Application No: FG/46/20/PL  
Site Address: The Tudor Close Public House Ferringham Lane Ferring BN12 5NQ  
Description of works: Conversion of the existing Public House (Class A4) to create 7 No residential units comprising 5 No 1-bedroom units & 2 No 2-bedroom units & the erection of 2 No 2-bedroom semi-detached chalet bungalows with associated car parking & landscaping. This application may affect a Public Right of Way.

Thank you for your internet representation made on 19th May 2020 which has been recorded as an objection with the comments as follows:

Ferring Parish Council object to elements of this proposal. The Tudor Close public house/restaurant has been a significant part of the community in Ferring for many years and a major feature of the street scene. While we understand the financial and commercial realities, we seek to ensure that any redevelopment is reasonable in its impact on the locality.

Drawing Title:
Elevations
As Proposed

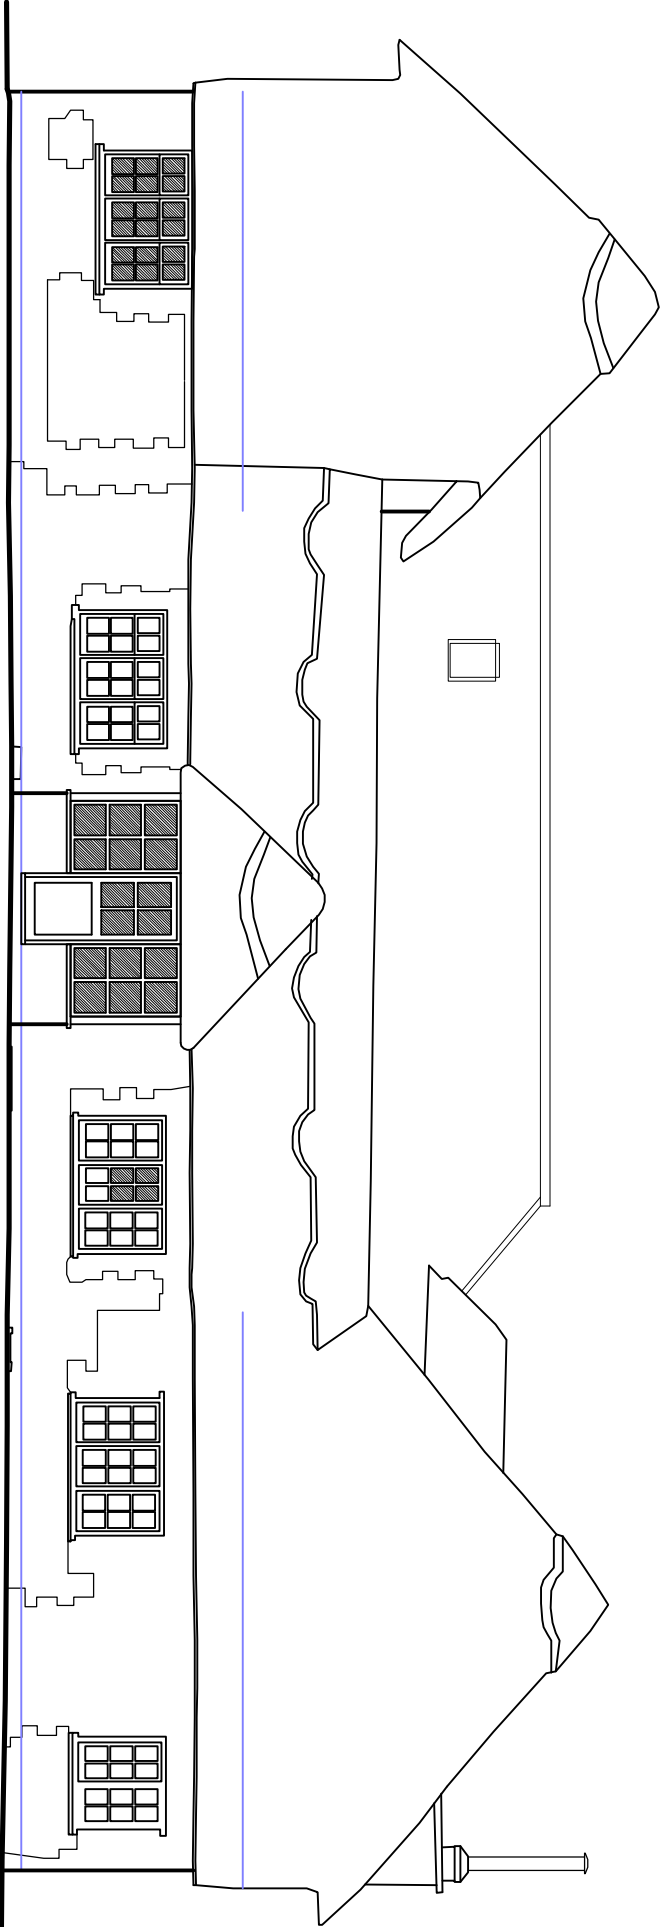
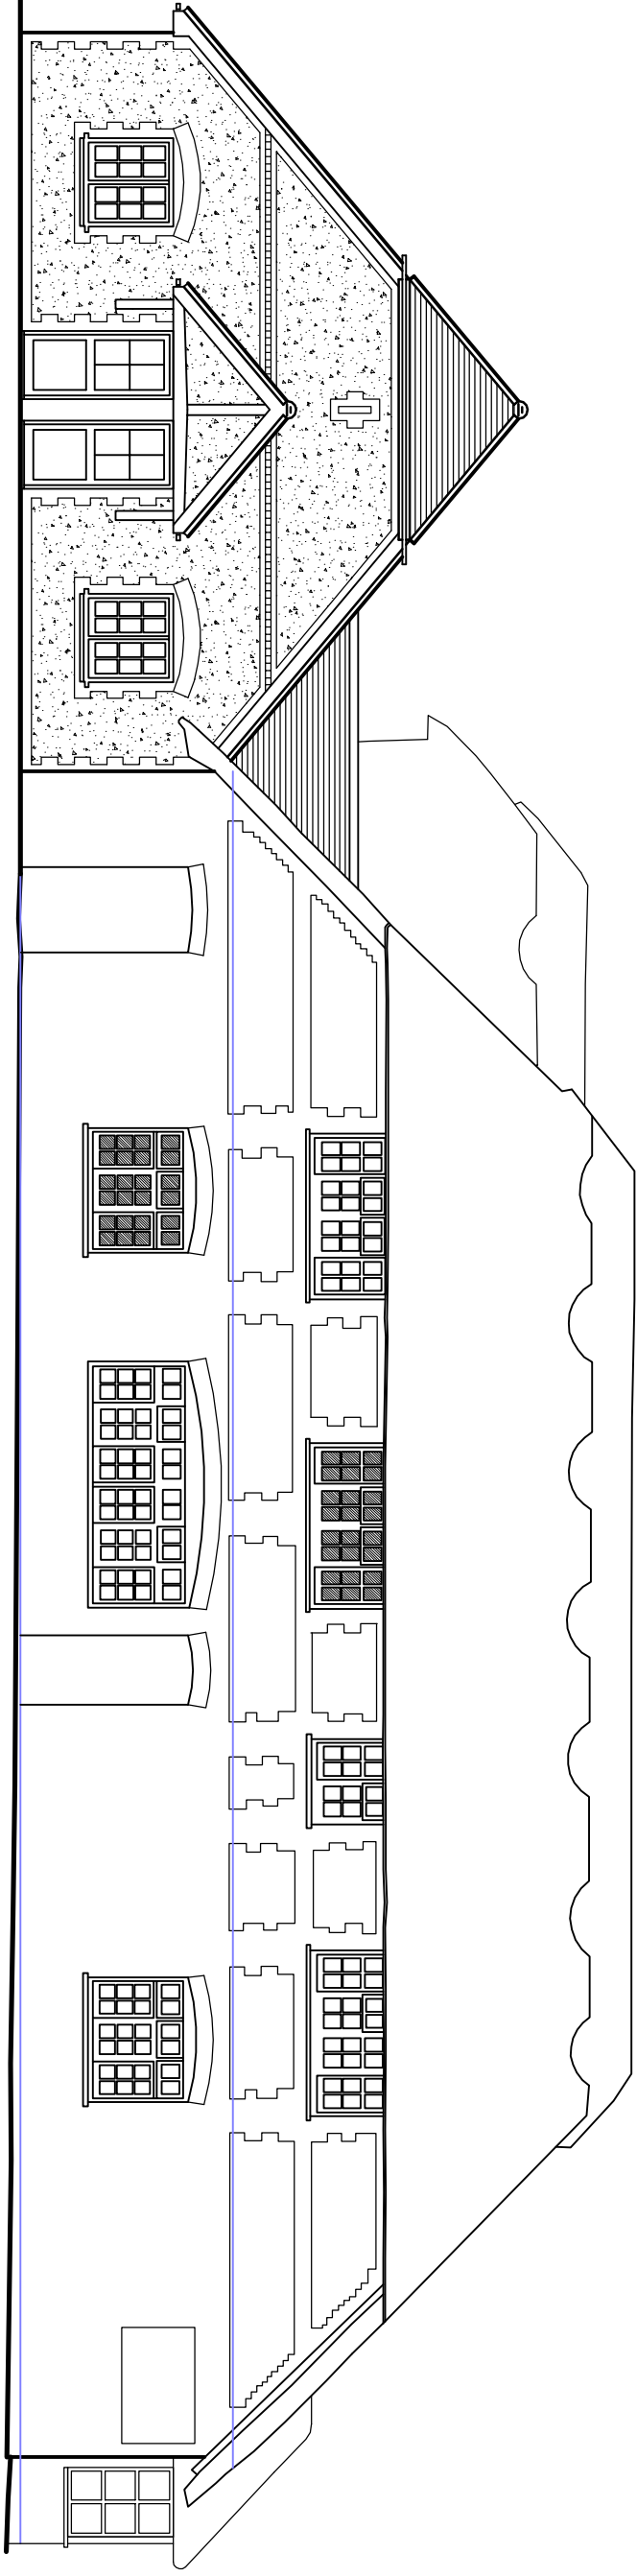
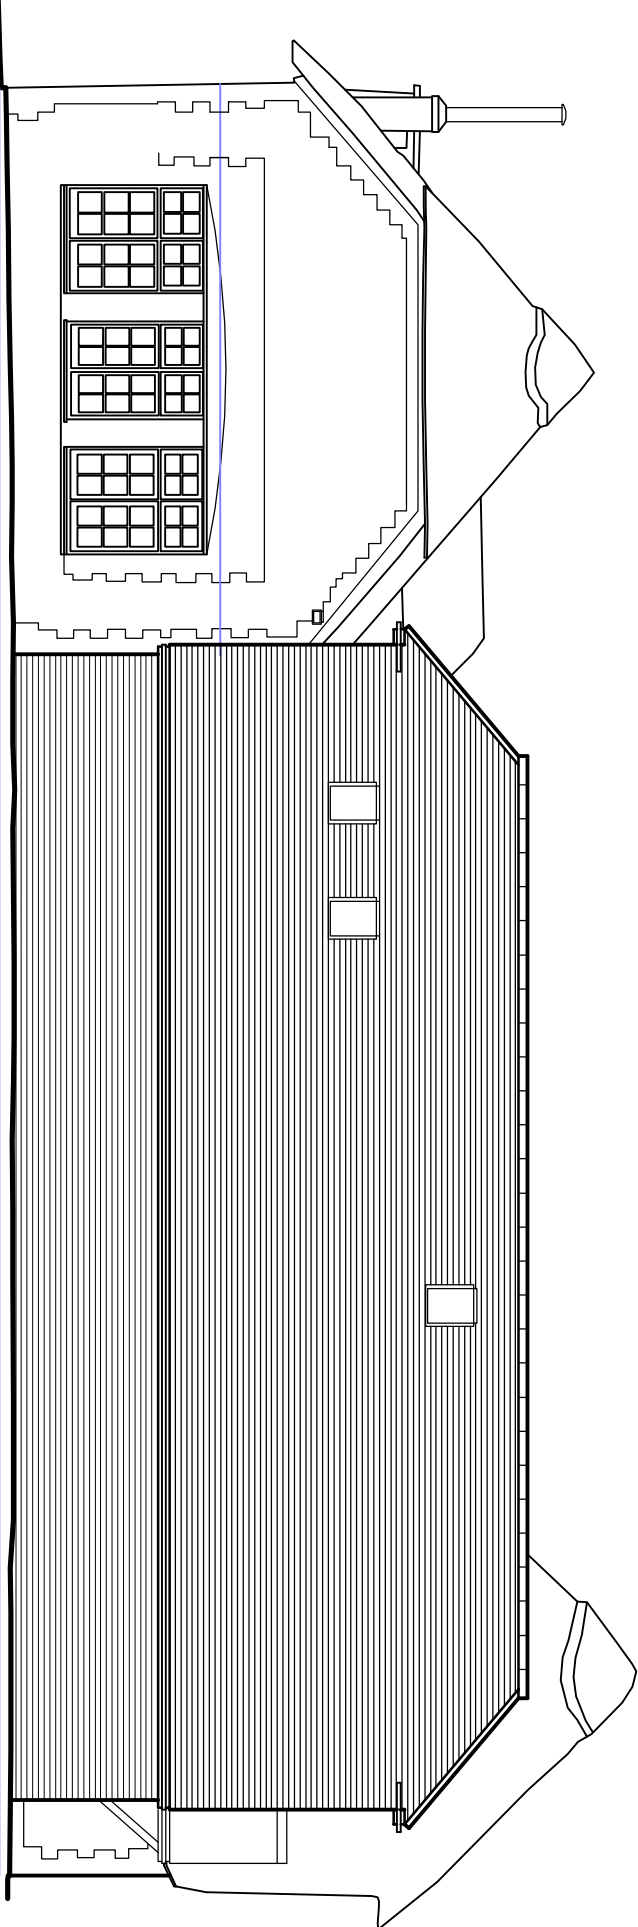
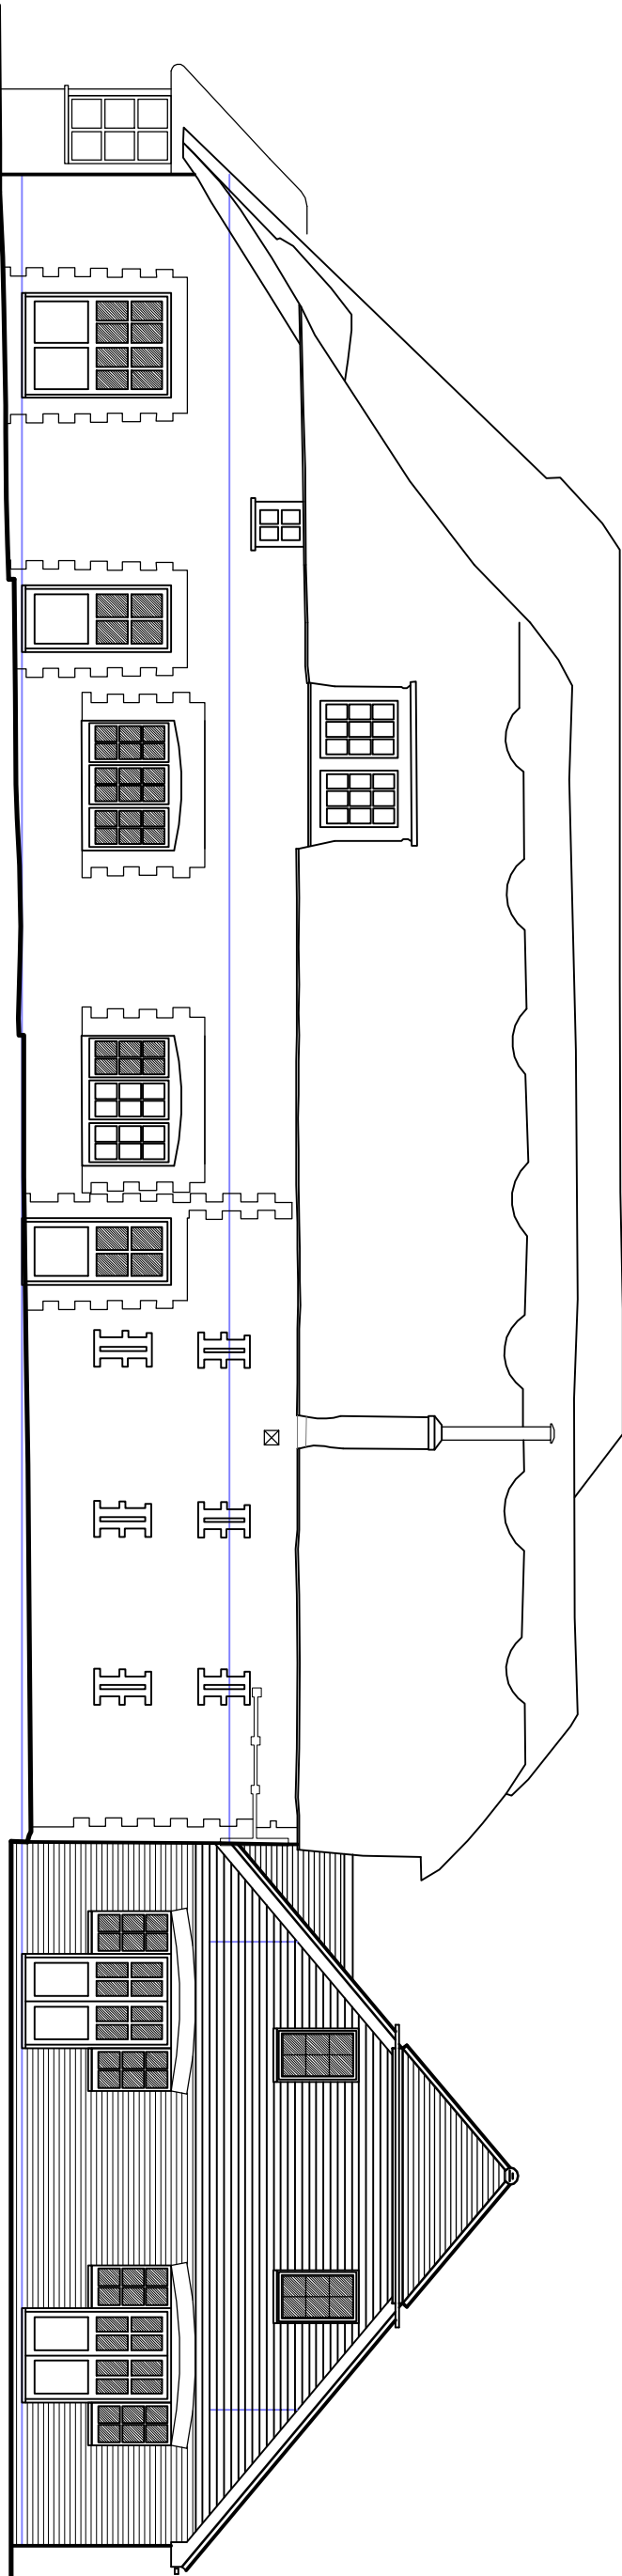
The height of the roof will be out of keeping when viewed from the north and overbearing for the properties to the south. The applicant recognises issues with overlooking by making the point in the application that the main windows on the first floor are at the western end to minimise overlooking. There do not appear to be any caveats to ensure that the south facing roof windows are obscured / fixed in support of that aim.

The thatched rooves are key a feature of the existing buildings and the dominance of the proposed new chalet roof will be in stark contrast. This conflicts with the Arun Local Plan policy for Buildings or Structures of Character in which this property is listed. The policy is specific in that "Alterations, extensions or other development which would adversely affect the appearance or setting of such buildings or structures will not be permitted." This proposal would clearly have such an adverse affect through the impact the proposed additional chalet properties would have on the site and existing listed Building of Character.
